Date:	12/6/16	Review Agency:	State Engineer
File Number:	SF-16-021, PUDSP-16-004	Reviewer:	_____
		Project Manager:	Nina Ruiz (719) 520-6313
Send response comments to: <u>DSDcomments@elpasoco.com</u>			
Project Name:	North Bay at Lake Woodmoor Final Plat, Preliminary Plan, Planned Unit Development		
Request:	A request by Lake Woodmoor Holdings LLC for a final plat to create 28 townhome lots, and 5 tracts on a 7.23 acre parcel presently zoned R-4 (obsolete). A PUD/preliminary plan is being processed concurrently. The applicants have requested a CLOMR from FEMA to realign the floodplain to that which is shown on the final plat drawing.		
Commissioner Dist:	1		
Tax ID# (s):	71114-04-111, 71114-00-007

Re: North Bay at Lake Woodmoor – PUD Development Plan and Final Plat

Subject: Northbay at Lake Woodmoor, SF-16-021, Review 1

SHEET
13
13 of 18 Sheets

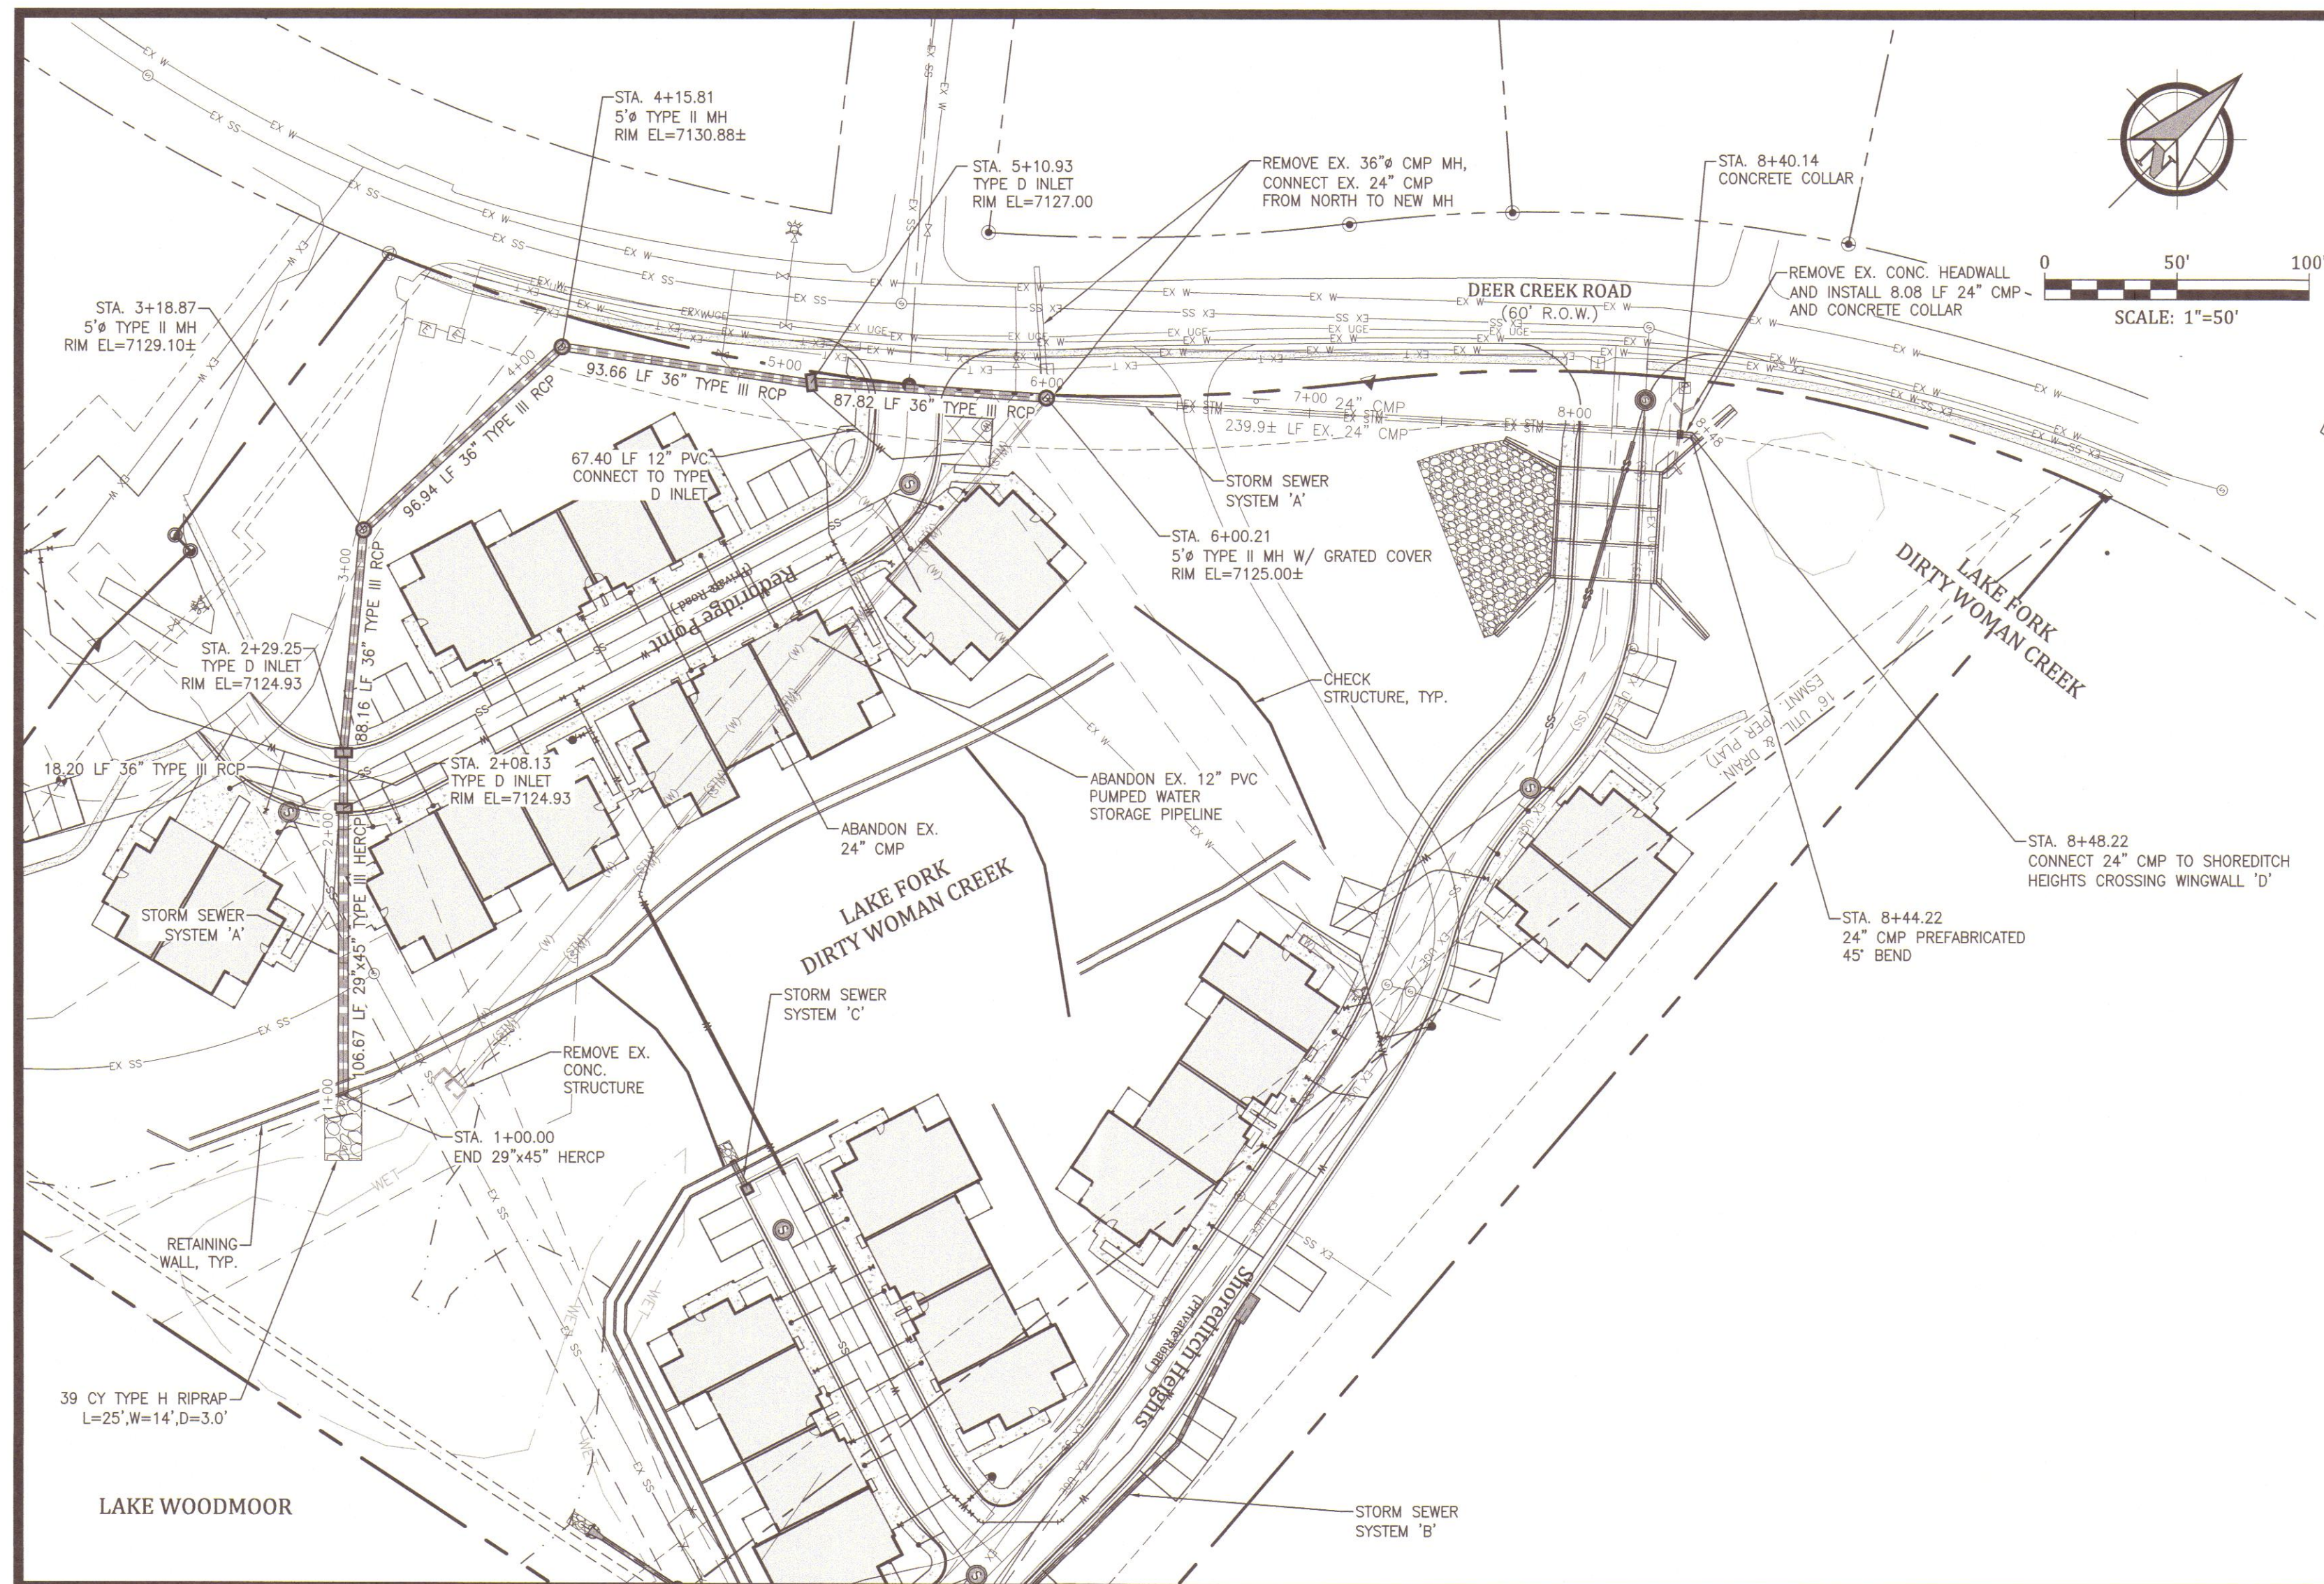
6. Storm P&P sheets (13 & 14)
 - a. Show the proposed lot lines.
 - b. Label the storm sewer systems and check structures as Private.
 - c. Place the segment of Storm System 'A' going through Lot 17 in an easement.
